CITY OF ALBUQUERQUE

February 27, 2025

**RE: Savio Ridge Subdivision
9601 Tierra Pintada NW
Grading and Drainage Plan and Drainage Report
Engineer's Stamp Date: 01/24/25
Hydrology File: J08D003B
Case # HYDR-2025-00009**

DATE: DECEMBER 2024

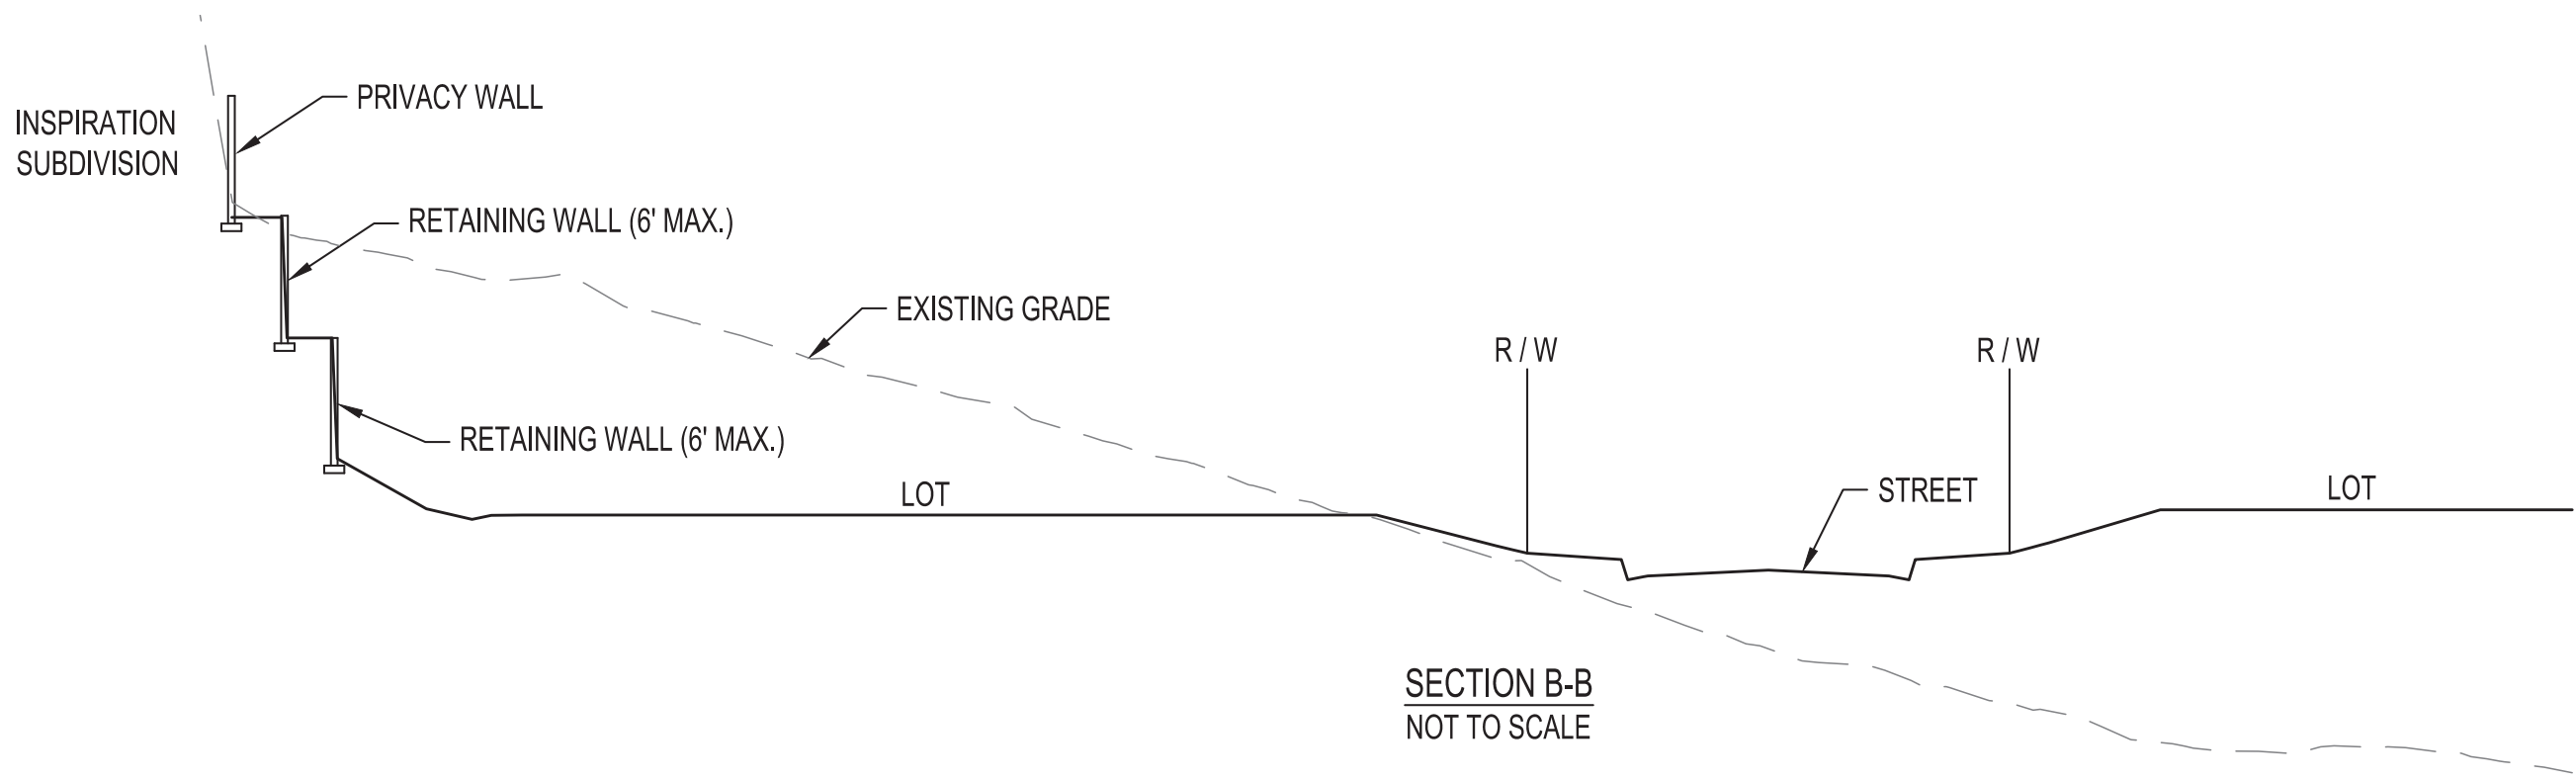
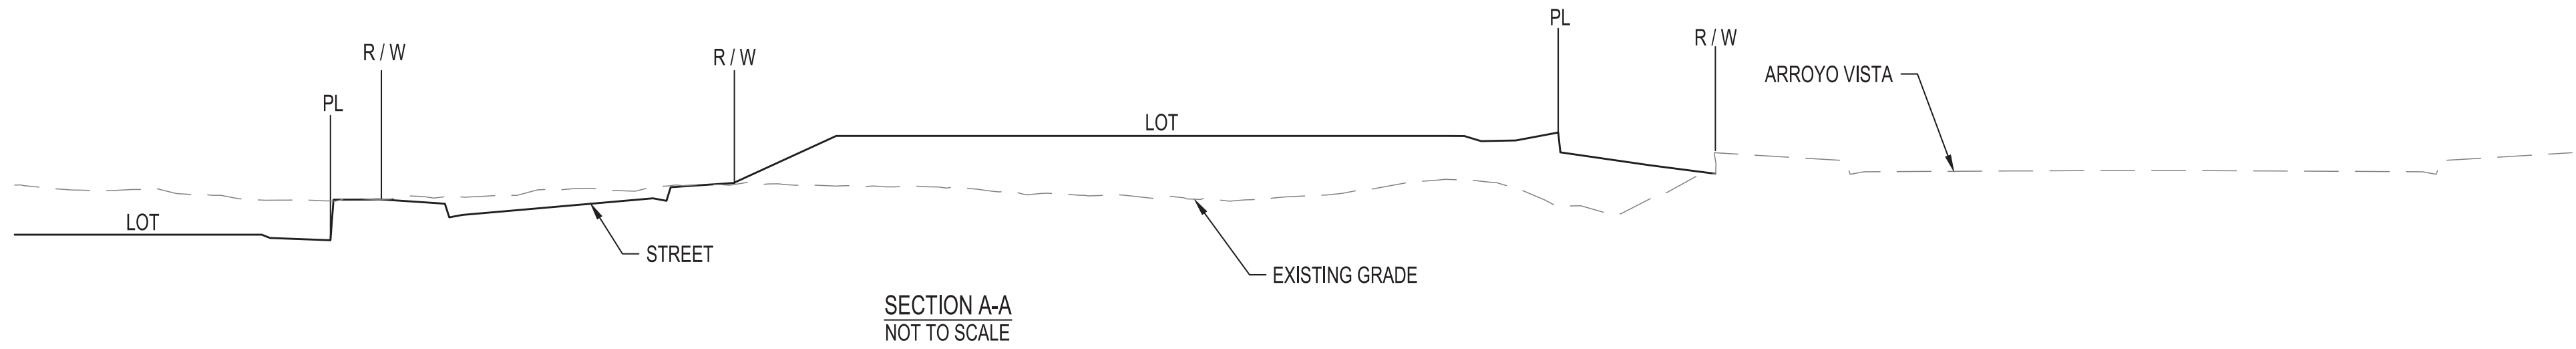
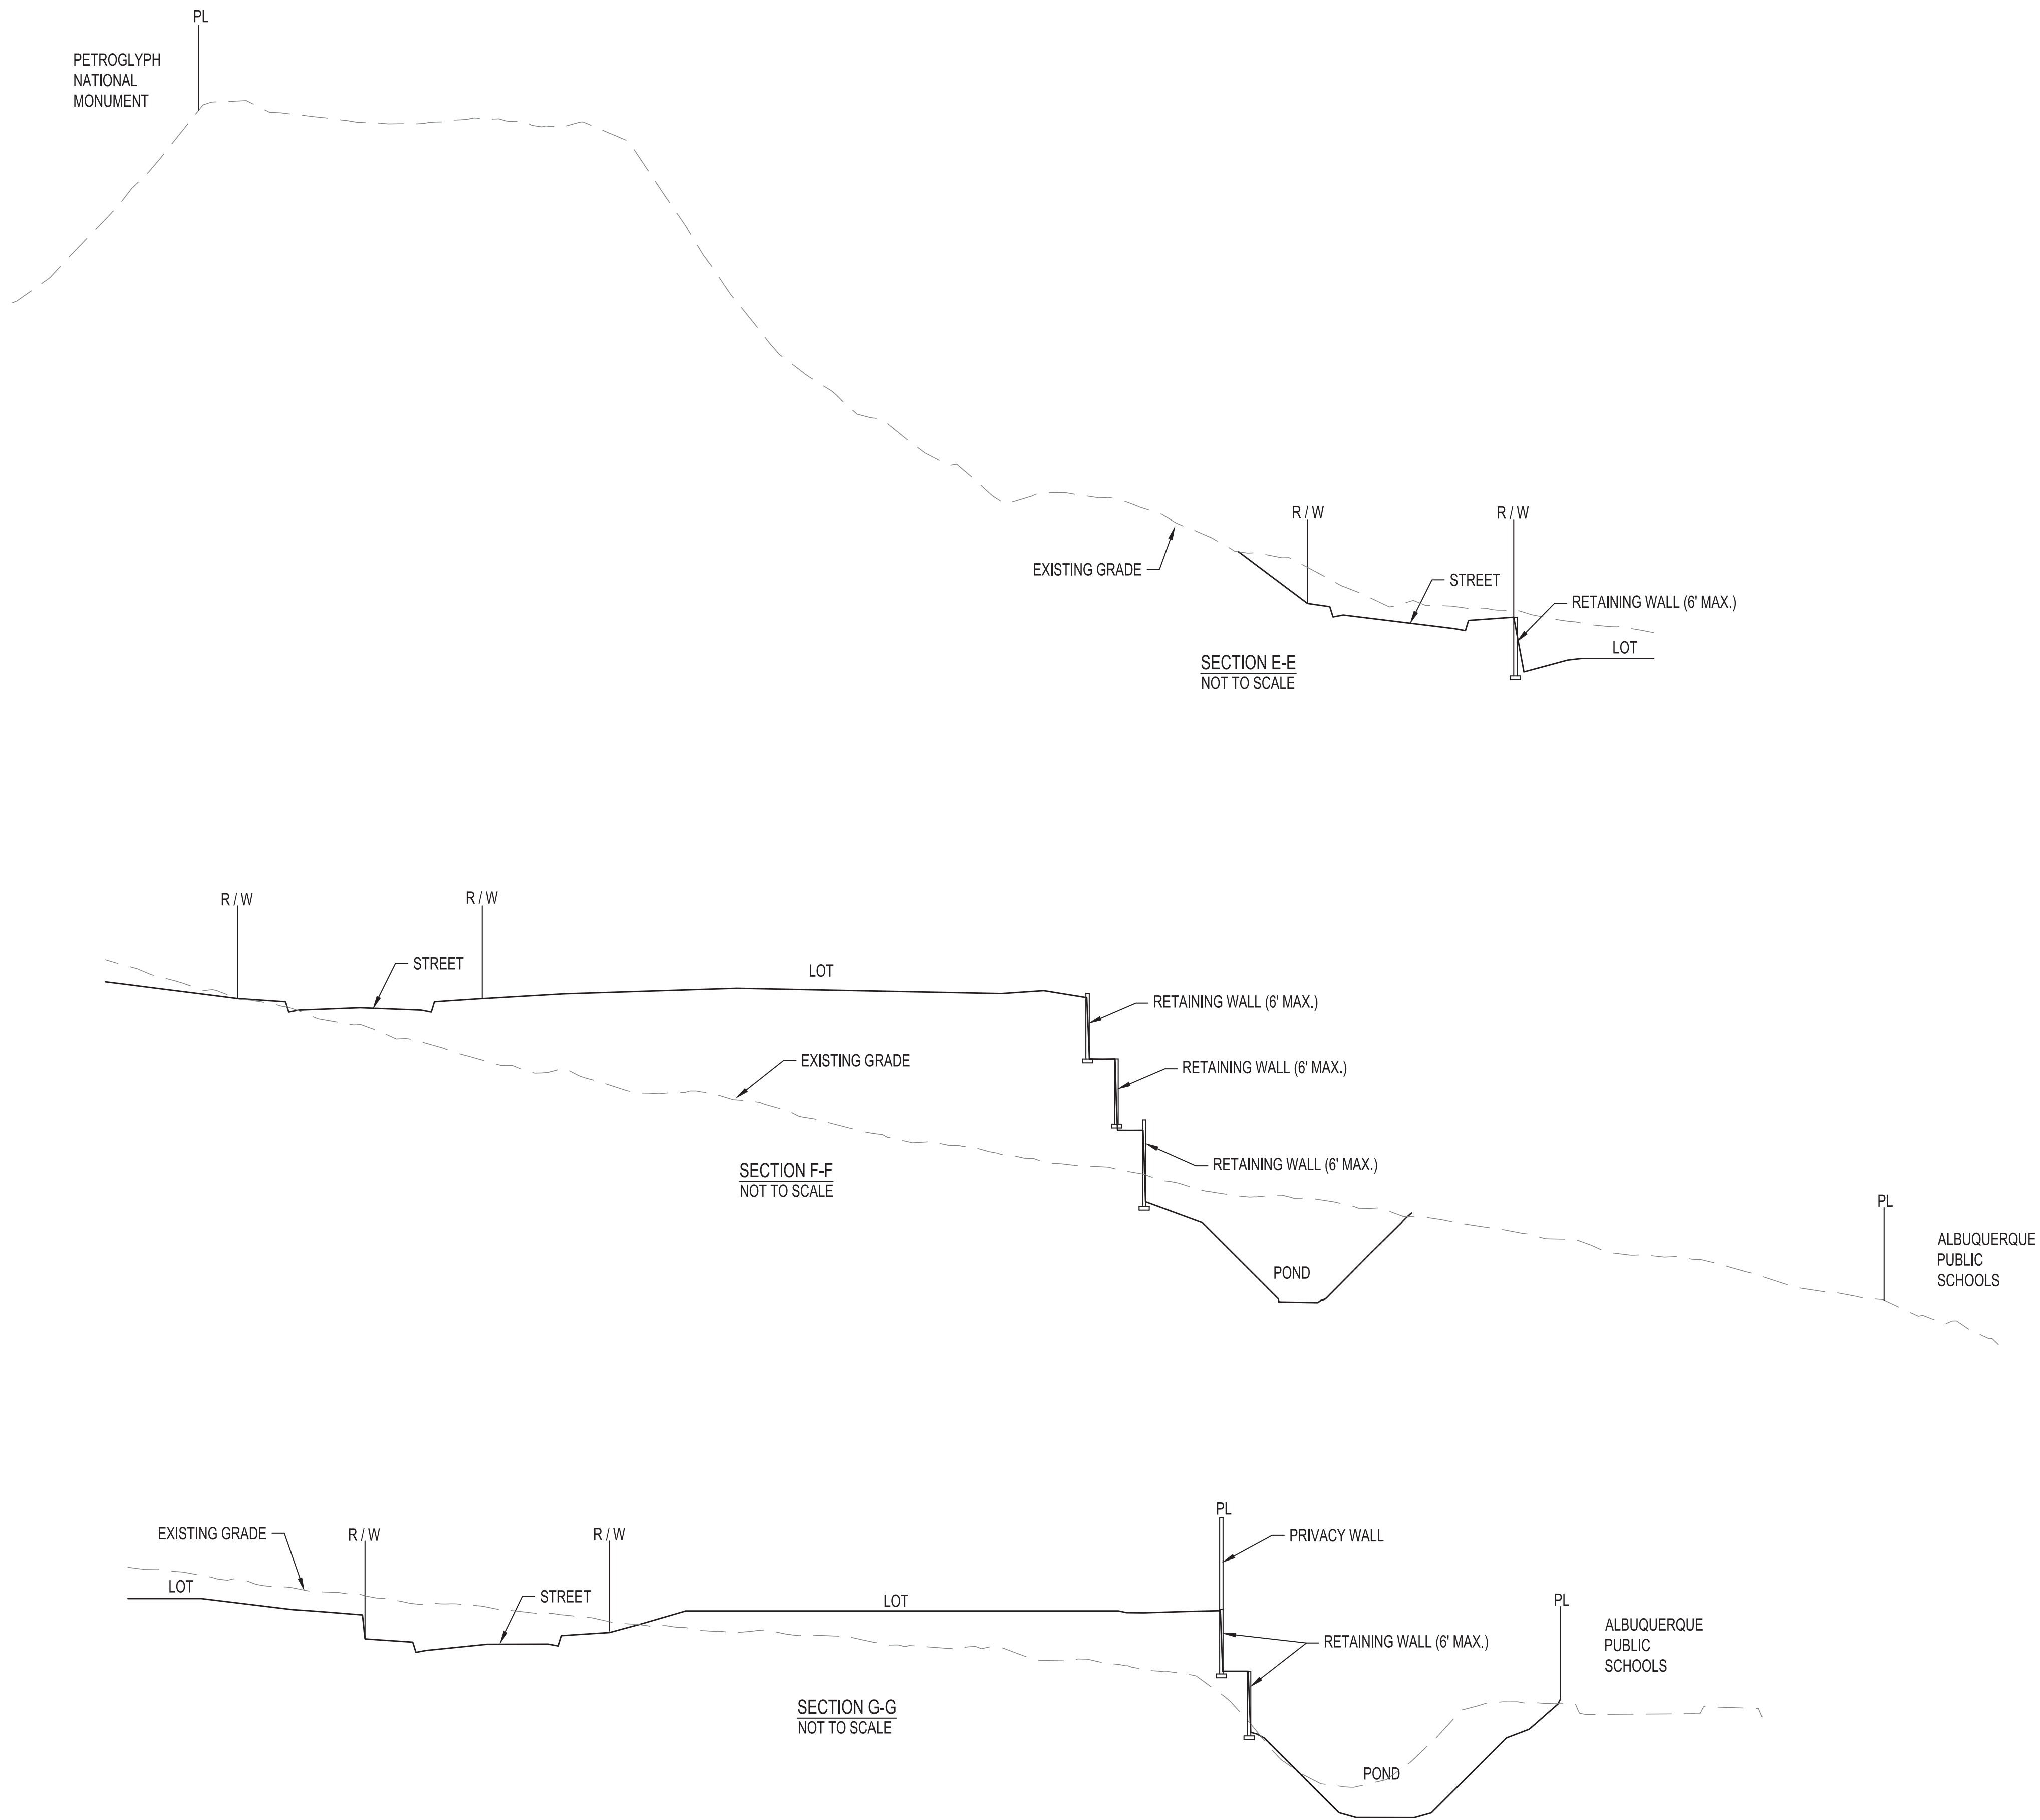
1. Since this project is adjacent to, or drains into an Albuquerque Metropolitan Arroyo and Flood Control Authority (AMAFCA) facility, approval by AMAFCA will be need prior to Hydrology approval. Please contact Jared Romero P.E, CFM (jromero@amafca.org or 505-884-2215).
2. Per the DPM, the following must be on the Grading Plan. Please note the Grading Plan must be a stand-alone construction document.
 - a. Please provide a Vicinity Map. This can be downloaded in pdf format from the City of Albuquerque's website.
 - b. Please provide the FIRM Map and flood plain note with effective date.
3. Please add a note on the Grading Plan to reference the Drainage Report for details related to the project conditions, requirements, and calculations.
